Forensic Pathology and Coroner's Court, SSD 16_7545

Frasers Property (formerly Australand) has been developing the Botanica estate in Lidcombe for over a decade. We strongly object to the proposal to locate the Forensic Pathology and Coroner's Court on the government owned site adjoining Botanica, specifically in relation to the proposed access from Main Avenue.

Figure 9 – Site Access Road

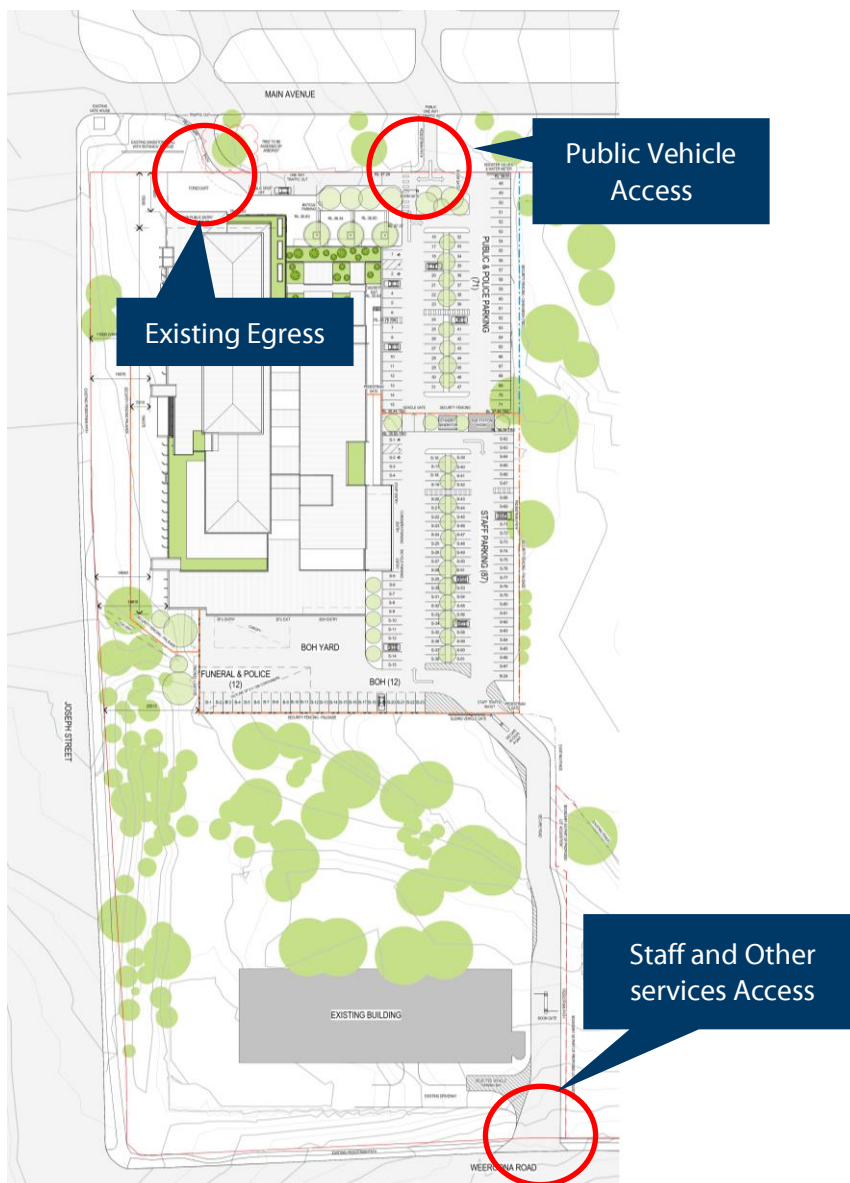
We note that the impact of the proposed development on Main Avenue is understated in the traffic report. Figure 9 nominates an "existing egress" from the site on Main Ave. Although a driveway exists in this location, it has not been used since prior to 2000.

There also appears to be a discrepancy between the stated use of the carparks and the traffic modelling. Section 4.1.1 of the report states that "Access for all staff and other users including the Police, Couriers and Engineers would be from Weeroona Road". However, Figure 9 labels the carpark off Main Avenue as being for "Public and Police Parking." The use of the Main Avenue car park by Police will increase the traffic impact on the residents of Botanica.
